**KIRKLEES METROPOLITAN COUNCIL
INVESTMENT & REGENERATION SERVICE**

**DELEGATED DECISION TO DETERMINE PLANNING APPLICATIONS TO
CARRY OUT DEVELOPMENT WITHOUT COMPLIANCE WITH PLANNING
CONDITIONS PREVIOUSLY ATTACHED**

Reference No:	2025/70/90642/W
Site Address:	31, Skelton Crescent, Crosland Moor, Huddersfield, HD4 5PN
Description:	Variation of condition 2 (plans) on previous permission 2024/92979 for erection of first floor front and side extension with dormers, rear dormer extension and car port
Recommending Officer:	Joanna Rednall

DECISION – VARIATION OF CONDITION 2 APPROVED

7 Proposed Site Plan
1 : 100

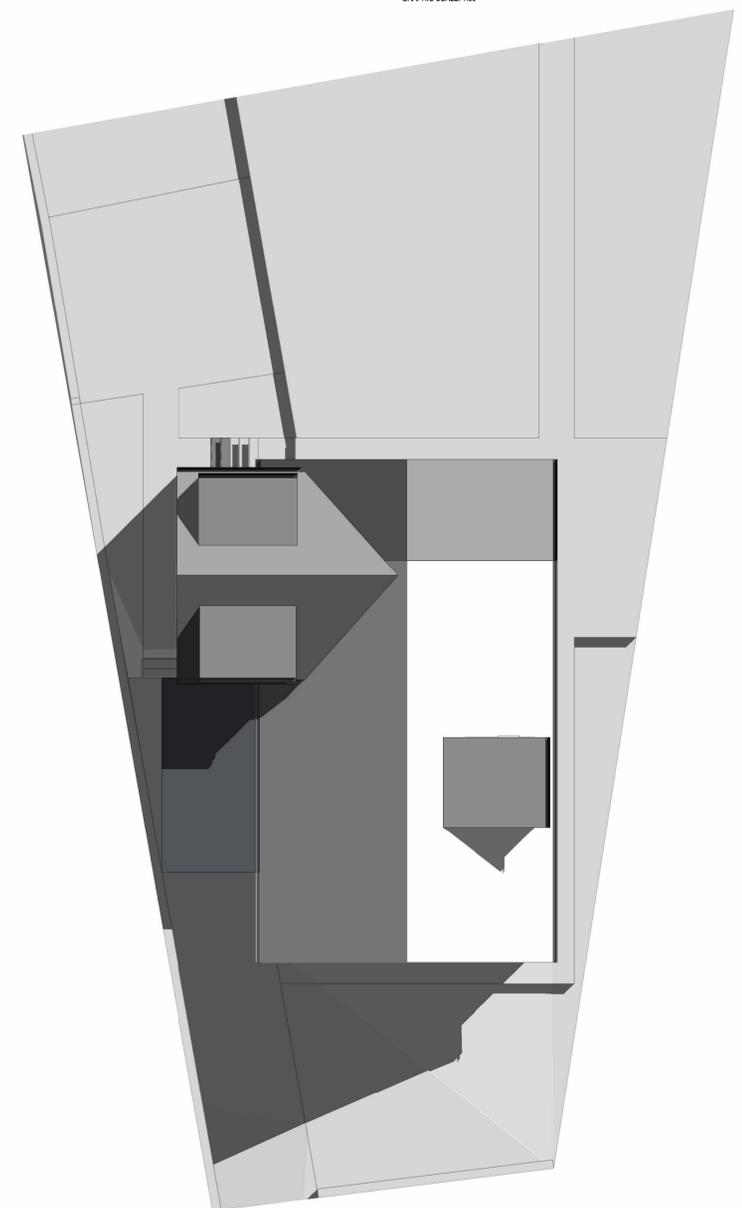
There are marginal increases to the car port which are considered acceptable.

The marginal increase to the car port will not have any greater impact on any nearby occupants.

3 (West) Rear Elevation as Proposed
1 : 50

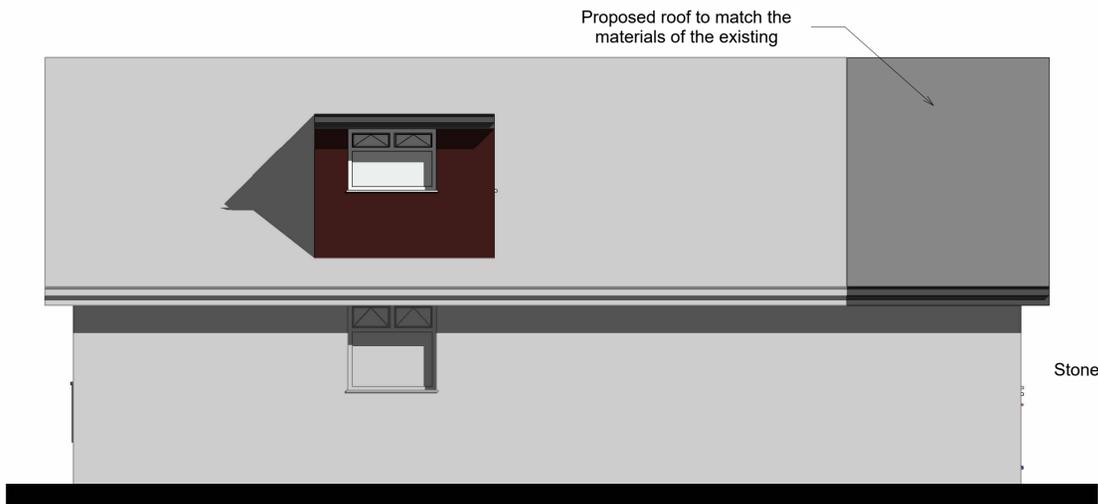
The variation to the approved plans includes the addition of a single window to the rear (west-facing) dormer. As this new opening is separated from No.29 by the main body of No.31, it is considered that the proposed change would not adversely affect the amenity of the occupiers of No.29.

The rear (west-facing) dormer currently includes an opening on its south-facing elevation, and this application proposes the addition of a further window on the west-facing elevation. This new opening would be located approximately 3 metres from the common boundary with No.35 and, as such, the primary consideration in assessing the impact of this variation is the potential for overlooking and loss of privacy.

Key Design Principle 3 of the Council's House Extensions and Alterations SPD recommends a minimum separation distance of 12 metres between windows of habitable rooms facing non-habitable room windows, and at least 21 metres between directly facing habitable room windows. The proposed window, which serves a bathroom, would directly overlook two openings on the east-facing elevation of No.35, Skelton Crescent, with a total separation distance of approximately 5 metres. Given the limited boundary treatment providing screening, it is considered that the new opening could result in an unacceptable level of overlooking. Therefore, should approval be granted, it is recommended that a condition be imposed requiring the window to be obscure glazed, in order to protect the amenity of the occupiers of No.35.

6. The development shall not be occupied until the west-facing dormer window, to serve the bathroom, hereby approved has been obscure glazed to a minimum Grade 4 Pilkington or similar. The obscure glazing shall thereafter be retained for the lifetime of the development.
Reason: In the interests of the amenity of the occupiers of neighbouring properties to accord with policy LP24 of the Kirklees Local Plan, Principle 3 of the adopted SPD on House Extensions and Alterations and Policies within Chapter 12 of the National Planning Policy Framework.
